WEST SUSSEX COUNTY COUNCIL CONSULTATION

TO:	Arun District Council FAO:Simon Davis
FROM:	WSCC - Highways Authority
DATE:	15 July 2021
LOCATION:	Rear of 34,36,38,40 & 44 Carlton Avenue Aldwick Bognor Regis PO21 3LR
SUBJECT:	AW/228/21/RES Approval of reserved matters following outline consent AW/130/21/OUT (layout, scale, landscape & appearance) for the erection of 8 No dwellings with access between 34 & 36 Carlton Avenue.
DATE OF SITE VISIT:	n/a
RECOMMENDATION:	No Objection
S106 CONTRIBUTION TOTAL:	n/a / £ See below for breakdown.

Parking Plan at 1:500 scale
WITH SWEEP PATH (ACCESS) OVERLAY

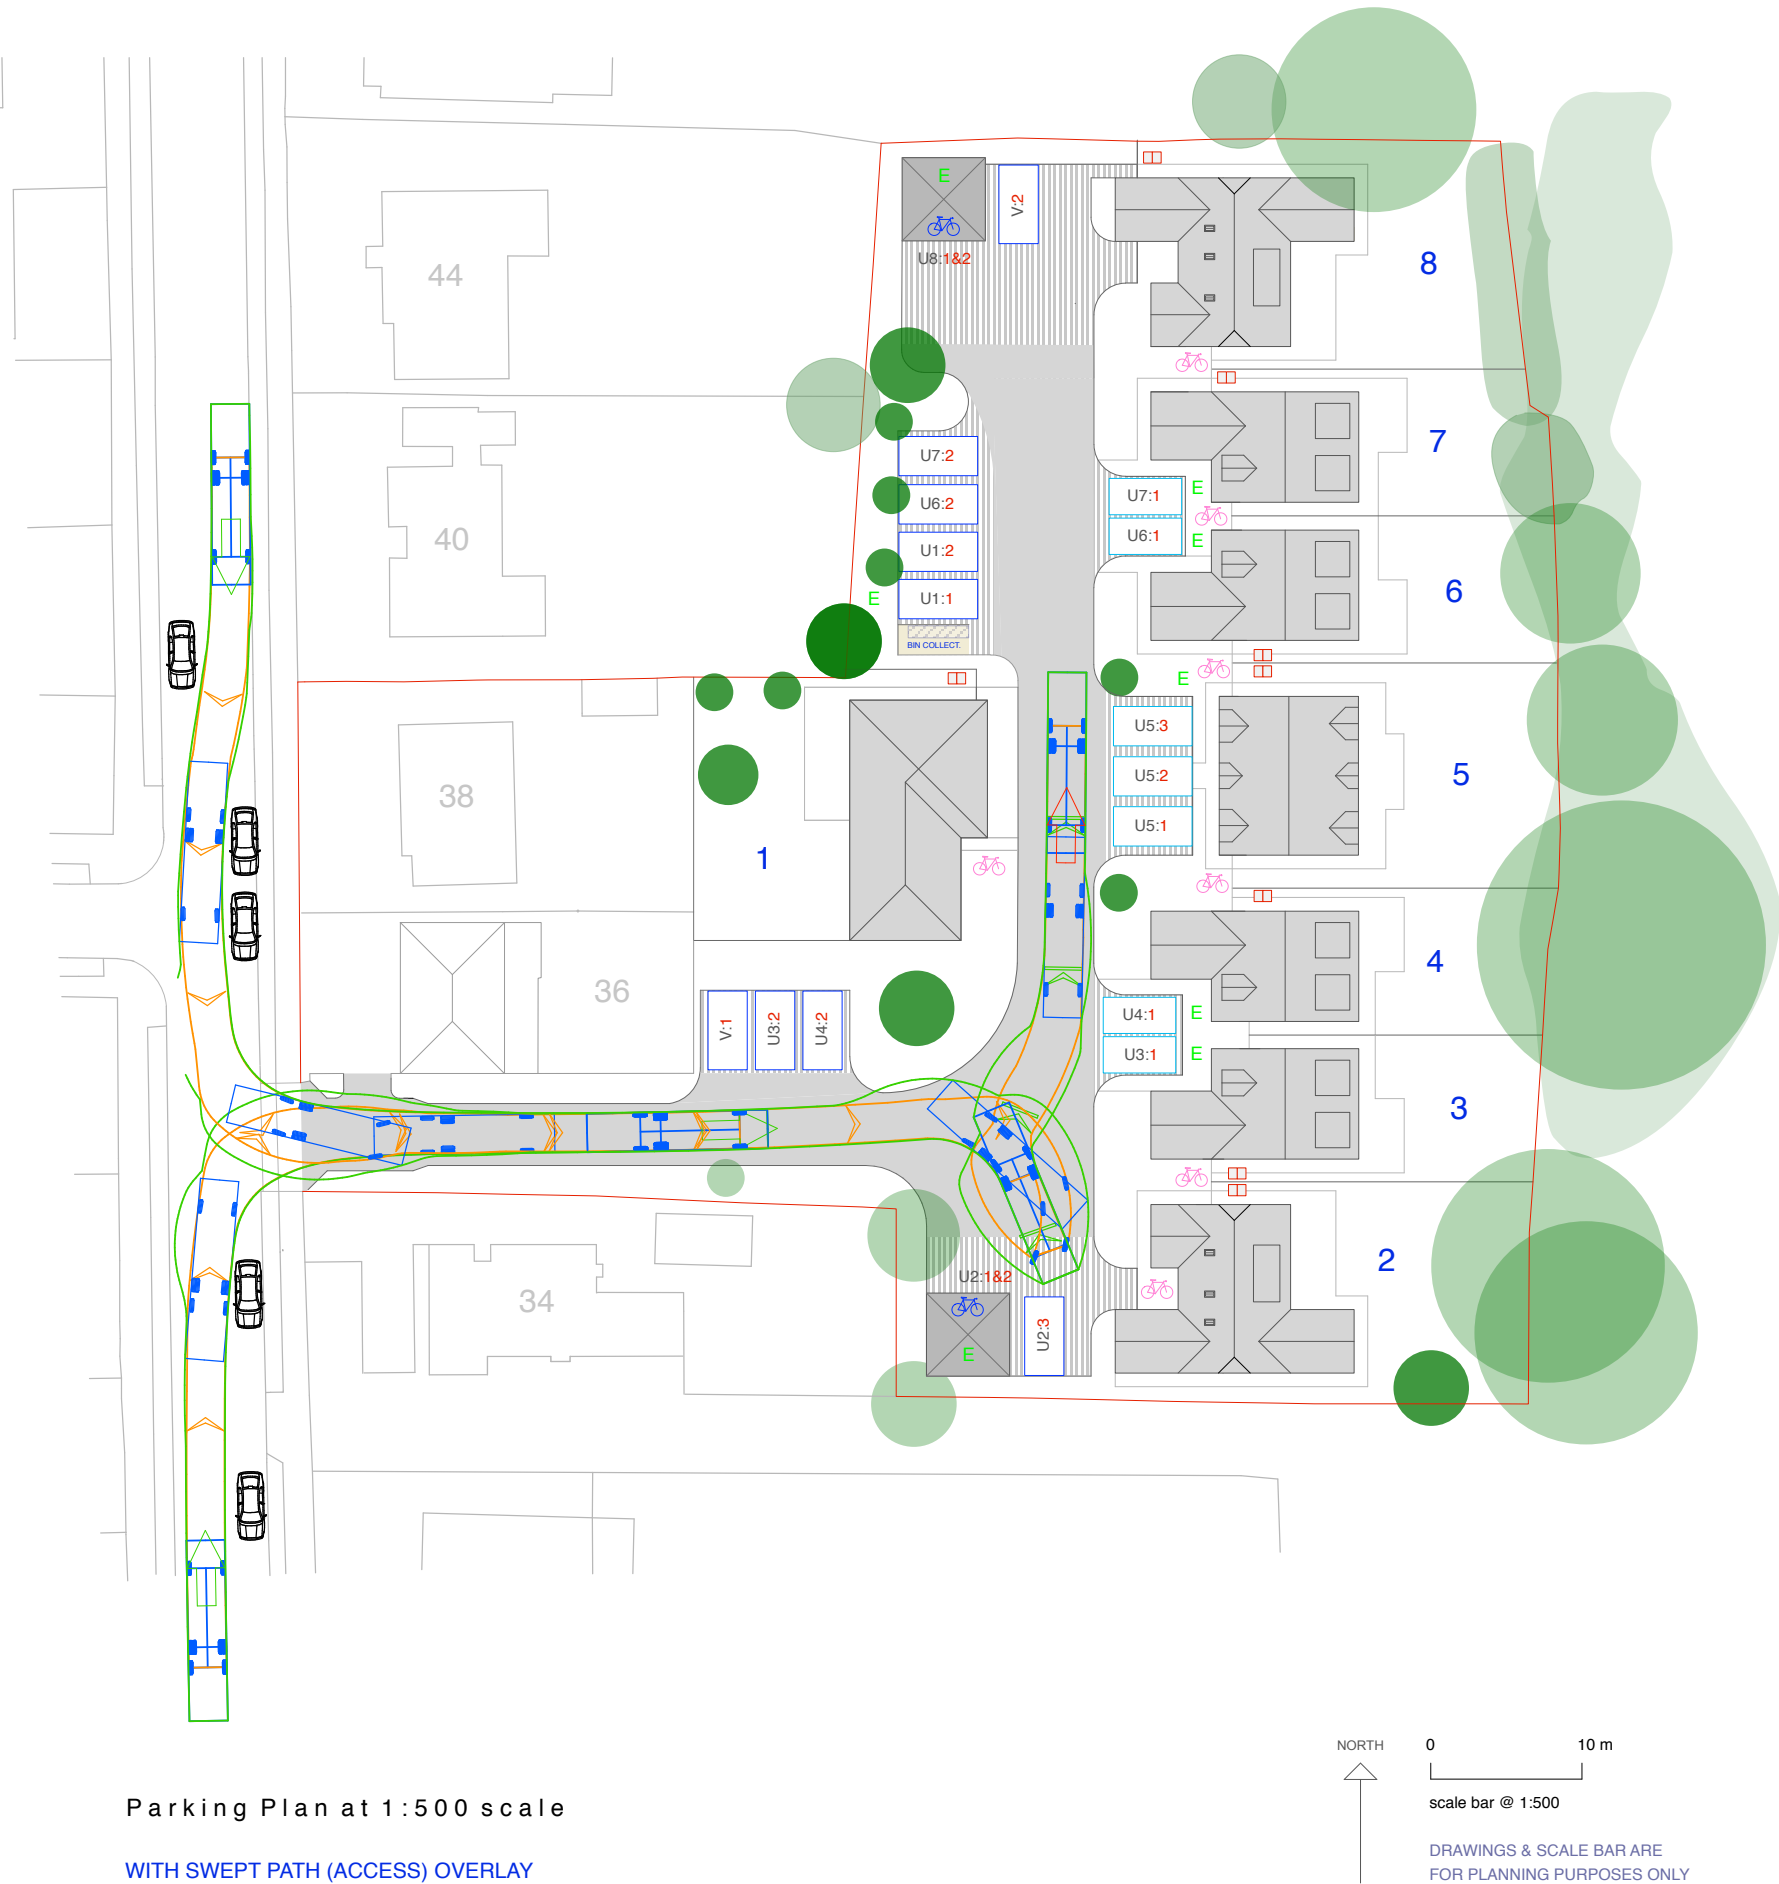
This provides a 4m access which is wide enough to accommodate a single vehicle, and given the straight alignment provides good forward visibility into the site. Swept path analysis of a fire appliance and refuse vehicle confirm this is possible and space is provided to allow turning at the end of this access point to allow for exit in forward gear.

As mentioned in previous comments the visibility splay over the bend should be protected and nothing over 0.6m planted to ensure this is maintained.

The parking space to the original plot 36 will join the new access road close to the entrance of the new access. Whilst this is only for one vehicle it is acknowledged the position of this could cause conflict, however given the small number of trips associated with the development, and the shared use layout of the site giving pedestrians more useable walking space it is felt that on balance this will not create a significant safety risk.

A parking layout plan has been submitted and provides 14 car parking spaces, and 2 visitor spaces. The final mix of housing will be 7 x 3 bed and 1 x 4 bed dwellings. WSCC has checked the car parking calculator for the use and the expected demand is as follows: -

The results from the calculator reveal a parking demand of 19 spaces. The parking proposal plan shows a generous allocation of parking with all 3 beds dwellings allocated 2 spaces, and each 4 bed

with 3. The site also provides parking for 2 visitors. Overall, this equates to 20 spaces which is over the expected demand. All spaces should be 2.4m x 4.8m or larger.

This is provided for each house, however details of this need to be confirmed as they should be in a secure and covered place. Where they are provided in garages, the garages need to be at least 3m x 6m to allow for both a car and bicycle to be stored.
